## DECISION DELEGATED TO DEVELOPMENT MANAGER

**Application No:** H01-1075-18      **Applicant:** Mr and Mrs M Laycock  
**Proposal:** Residential development (3 dwellings) - approved under H01-0759-18 - Modification of Condition 8 relating to visibility splays  
**Location:** 68 Stone Gate Cowbit Spalding  
**Terminal Date:** 19th December 2018

Residential development (3 dwellings) - approved under H01-0759-18 - Modification of Condition 8 relating to visibility splays.

Proposed Site Plan (1:250)

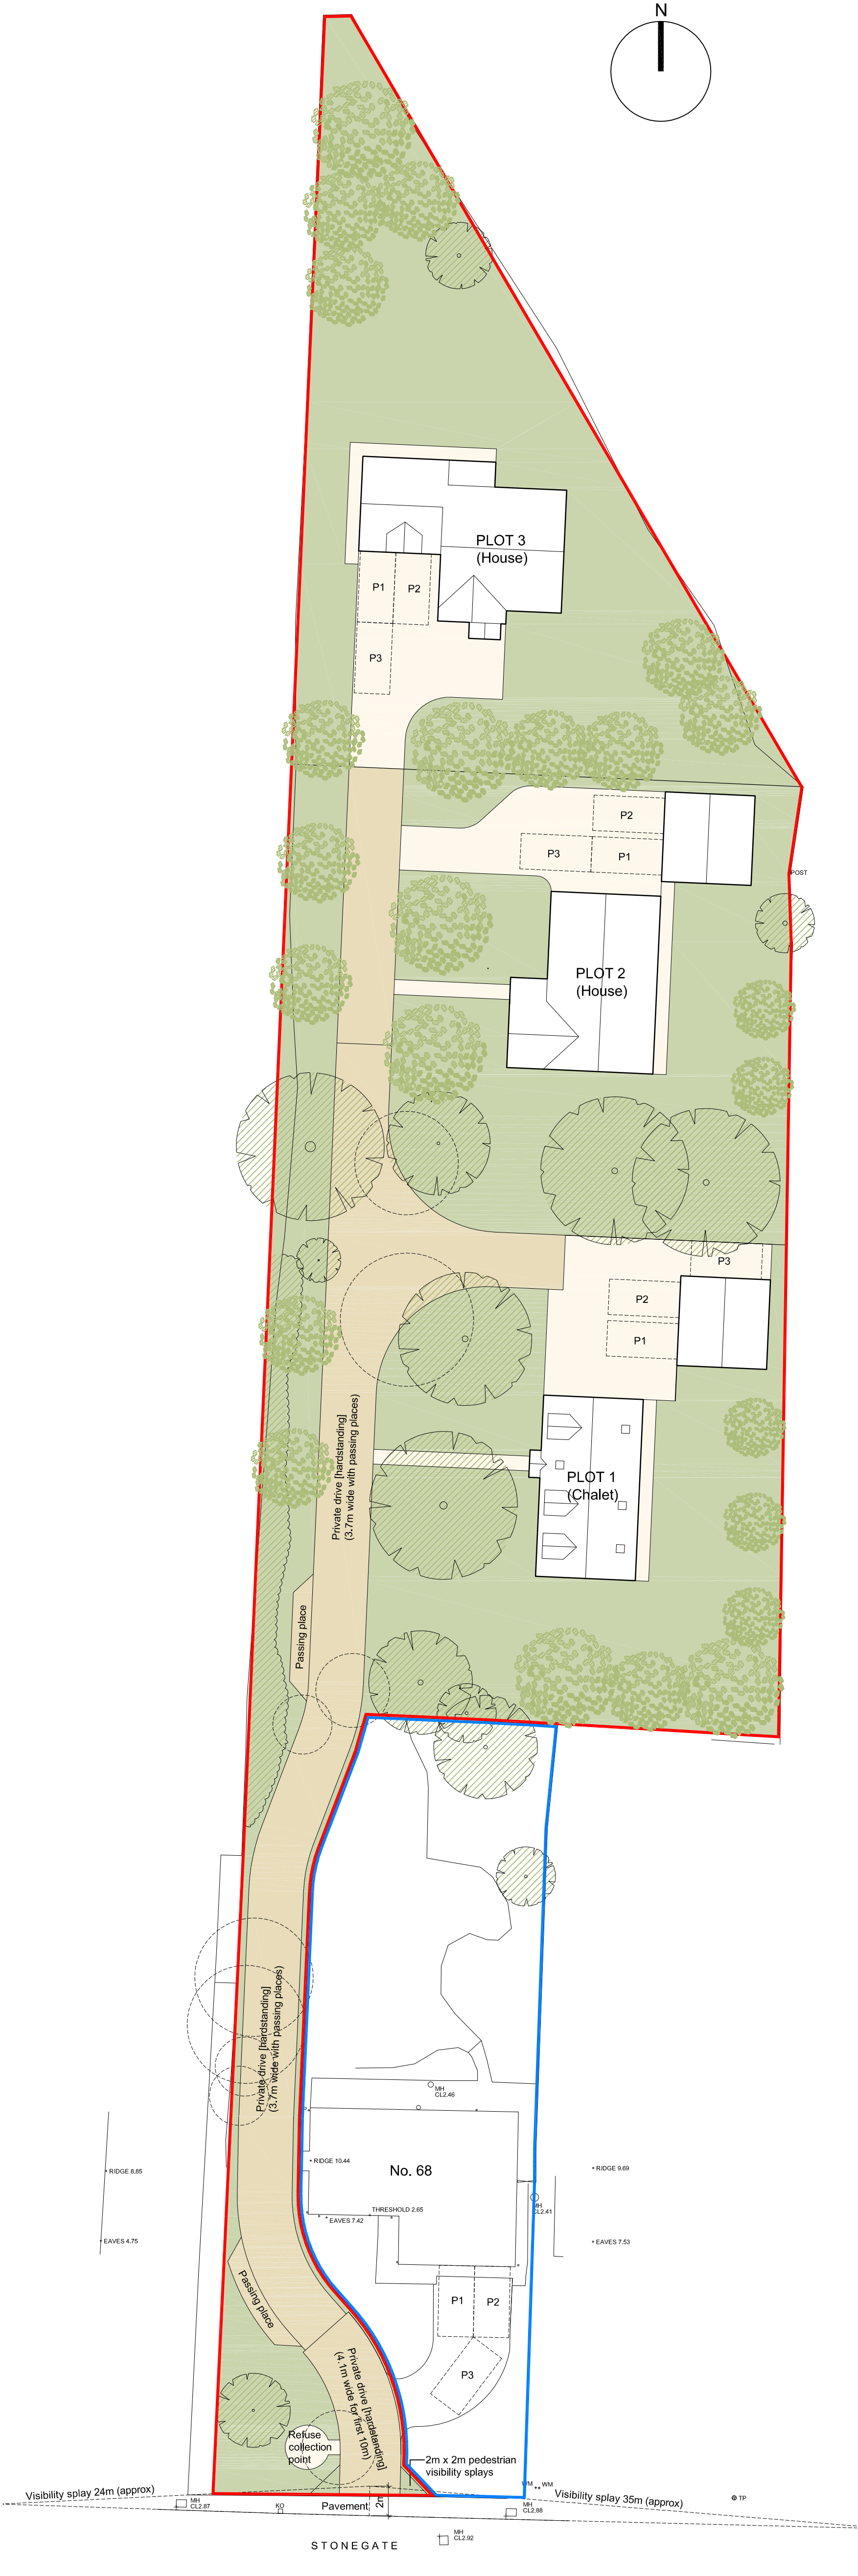
The Application talks of a visibility splay of 2m x 37 m (west) & 2m x 34m (east), however the submitted plan shows visibility splays of only 2m x 24m (west) and 2m x 35m (east).

The block plan does not show how the proposed visibility splays can be achieved and does not match with the statement.

The previous planning condition required a visibility splay of 2m x 43m and this should be considered a minimum.

The details of the current submission have been assessed by LCC Highways officers again and no objection is being raised to the reduction of the vision splays for this site. The plans and details and conclude that there is no reason for objection to the reduction in sight lines to 2.0m x 37m (to the west) and 2.0m x 34m (to the east), as requested by this application.

An objector has raised an apparent discrepancy in the submitted plan and application, however the submitted location plan is to be used for reference purposes and is not intended to set the vision splays, as this is controlled by condition.
